DOC17/20272-03, File No. EF13/3519

**RIX'S CREEK EXTENSION PROJECT SSD 6300
ADDENDUM RTS-MAIN REPORT-SUPPLEMENTARY ADVICE**

I refer to your email dated 16 January 2017 in respect of Rix's Creek Extension Project SSD 6300 and the document titled "*Rix's Creek Continuation of Mining Project Response to Submissions Addendum*" dated 21 December 2016 prepared by AECOM ("Addendum RTS") and the Environment Protection Authority's ("EPA") letter to Department of Planning and Environment ("DPE") dated 25 January 2017.

Figure 9-6: Predicted 24-hour average PM₁₀ concentrations for Receptors 61, 140 and 19 in Year 2017

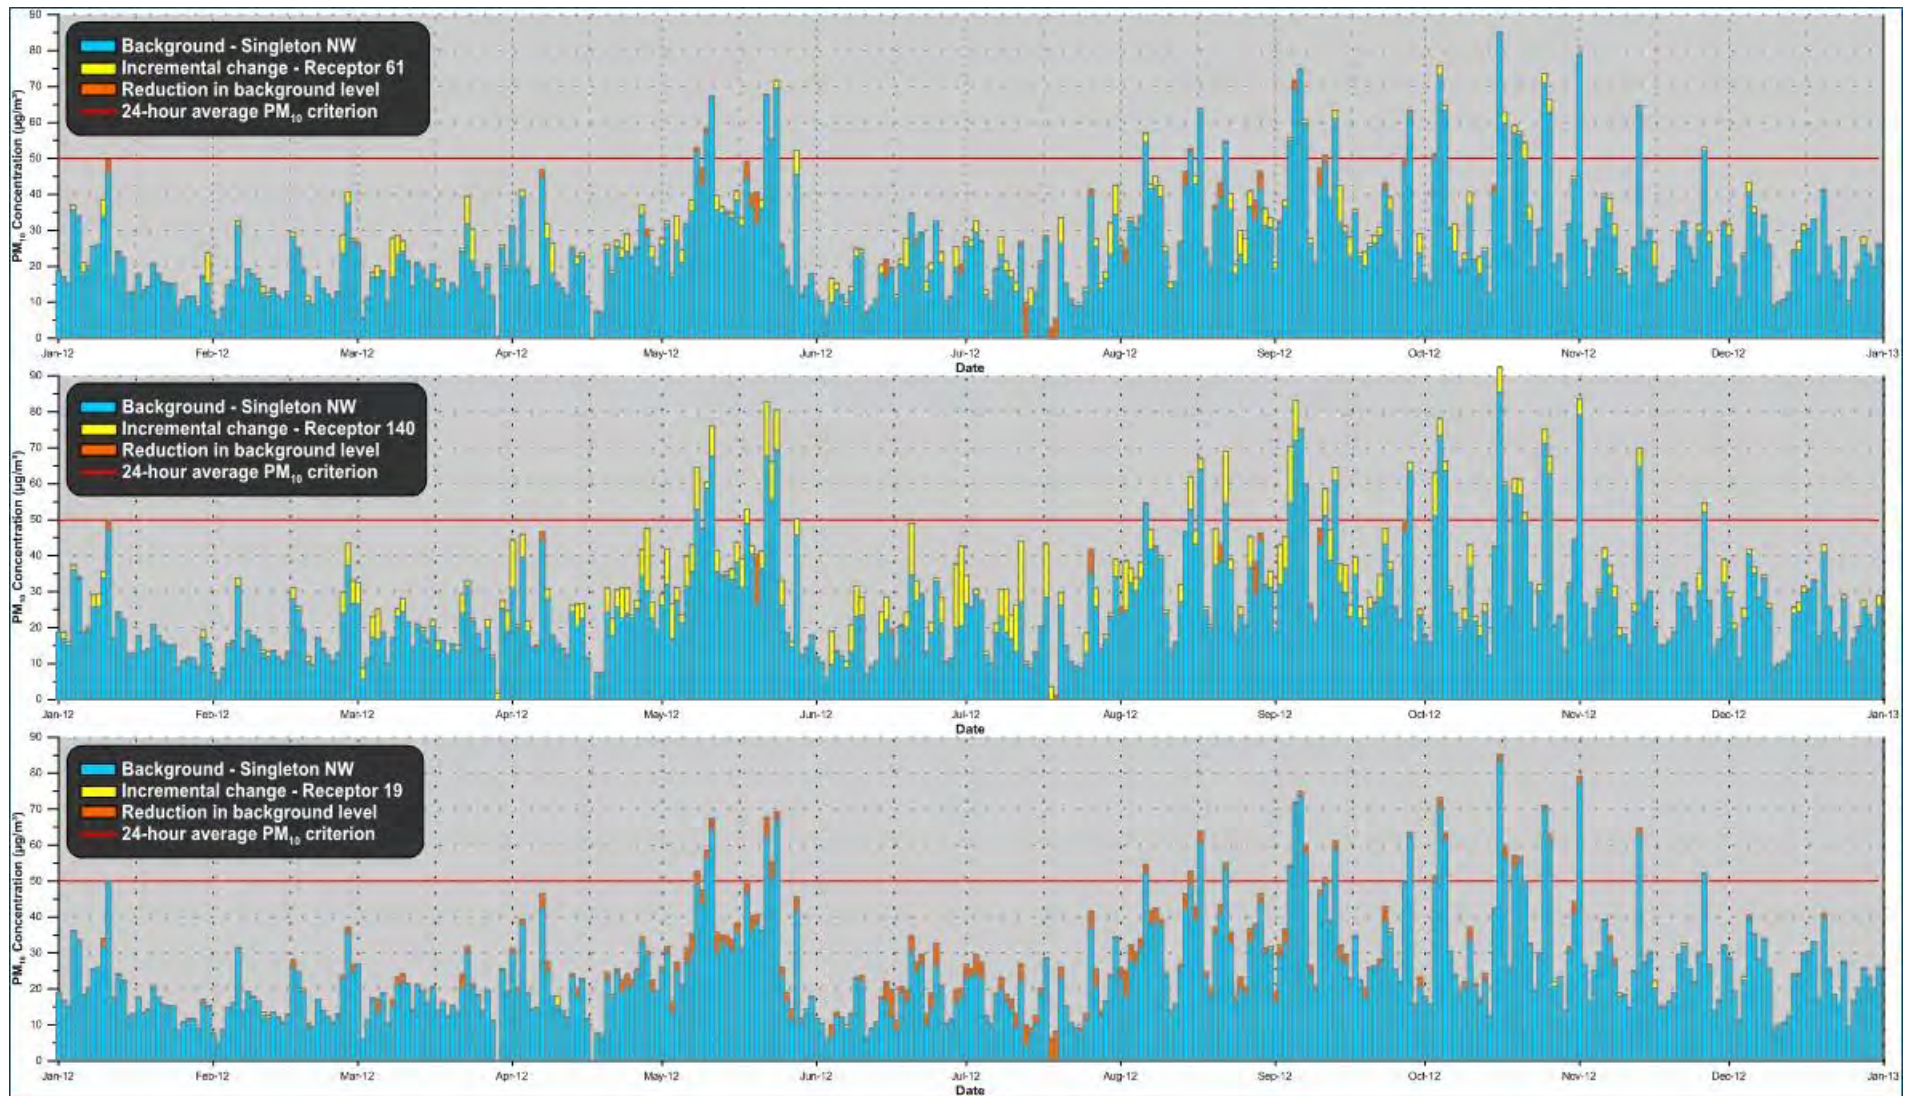
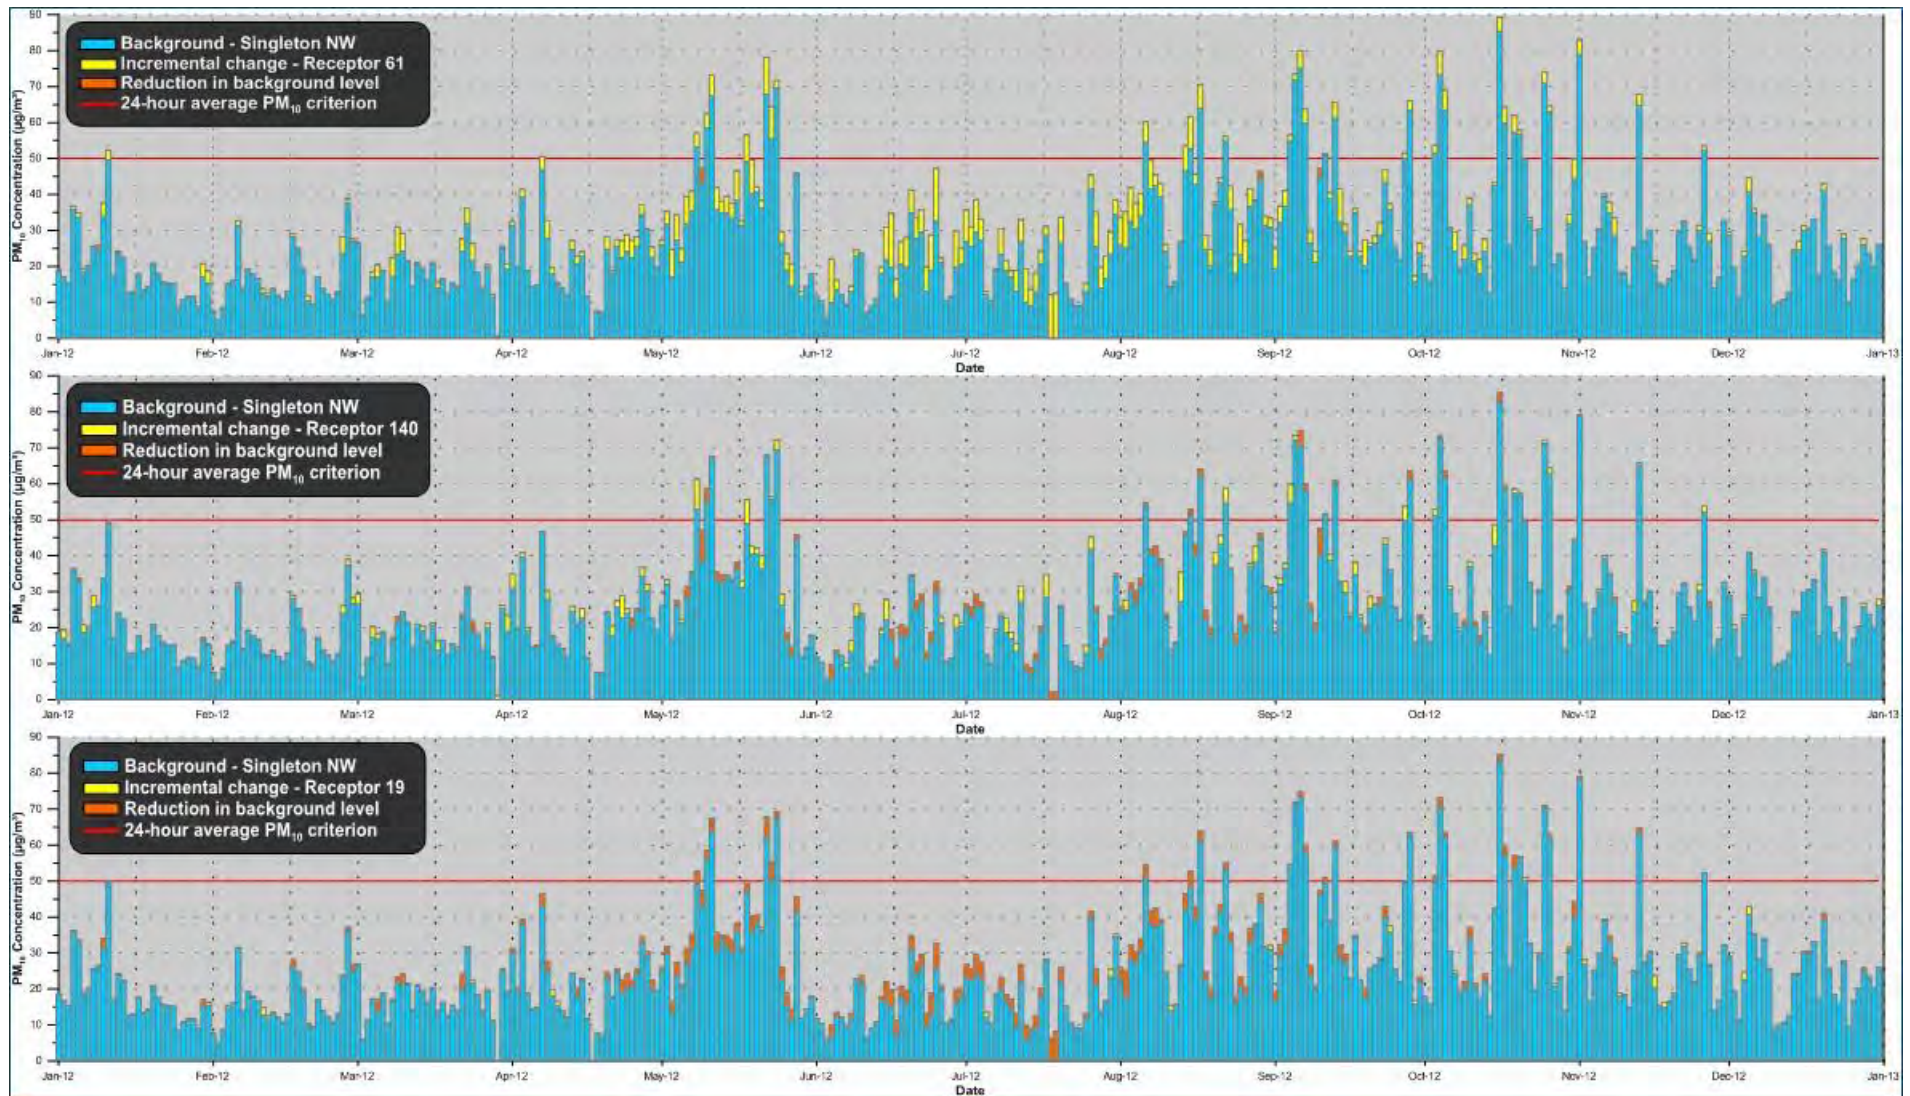
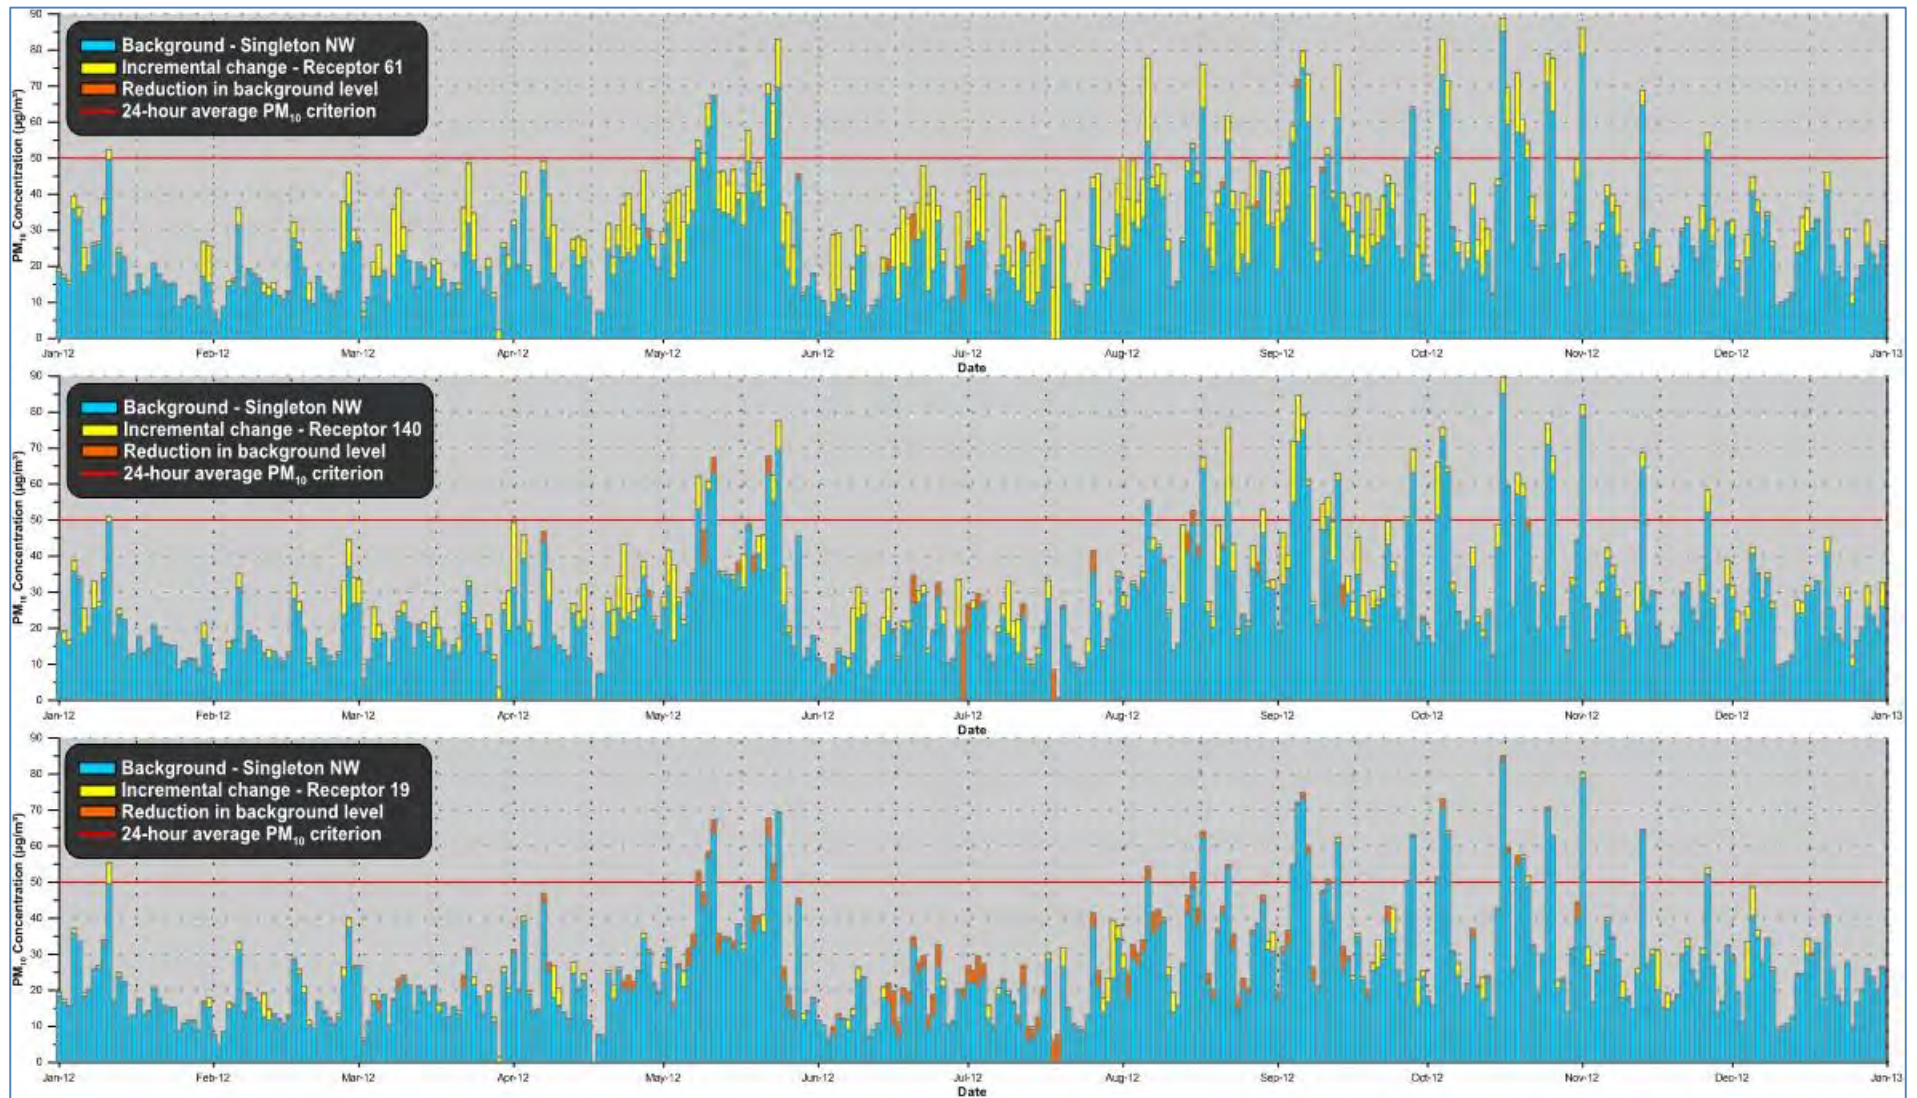
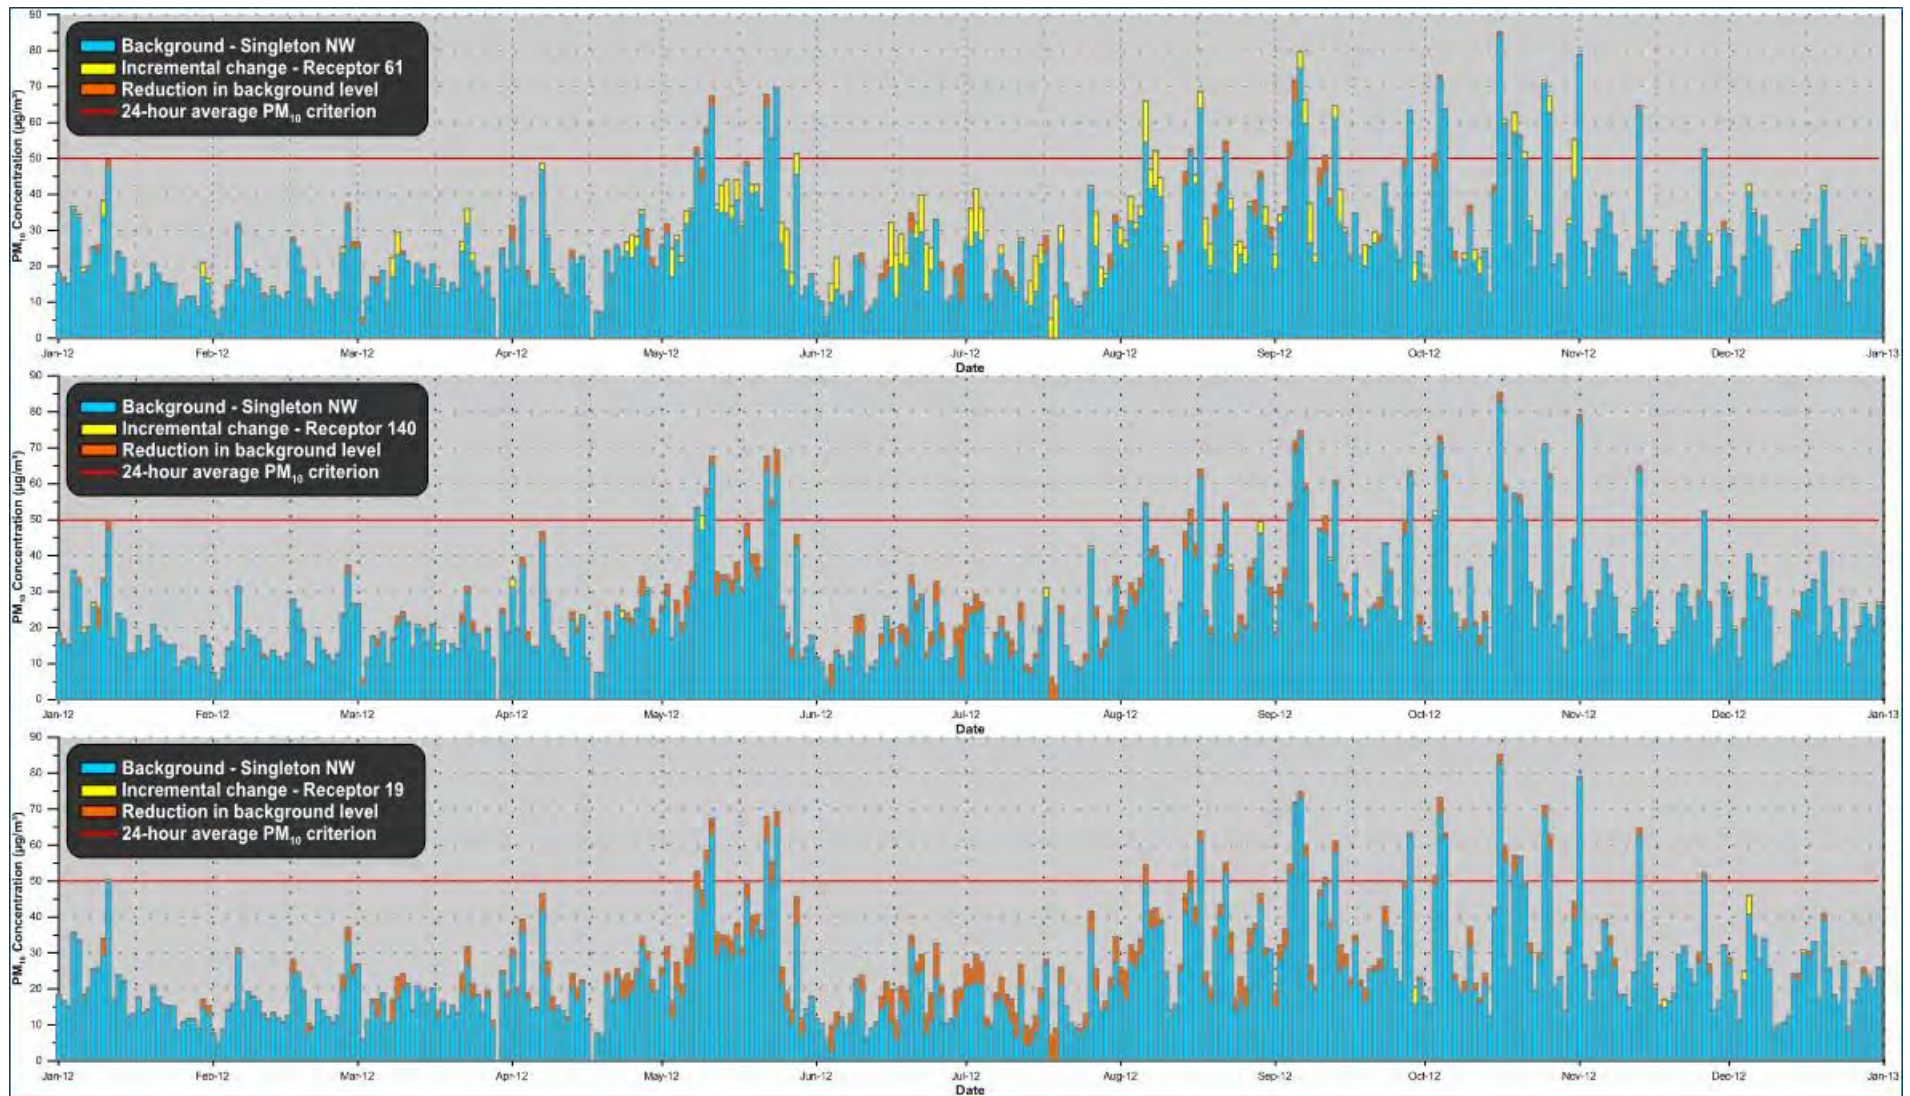
3. The assessment states that to evaluate potential exceedances of the EPA's 24-hour PM₁₀ criterion, impacts were assessed for a set of receptors chosen to surround the mine. Exceedances of the criterion were found for six of these -19, 61, 140, 151, 163, and 164. The EPA advises that other receptors close to these may also exceed the EPA's 24-hour PM₁₀ criterion.
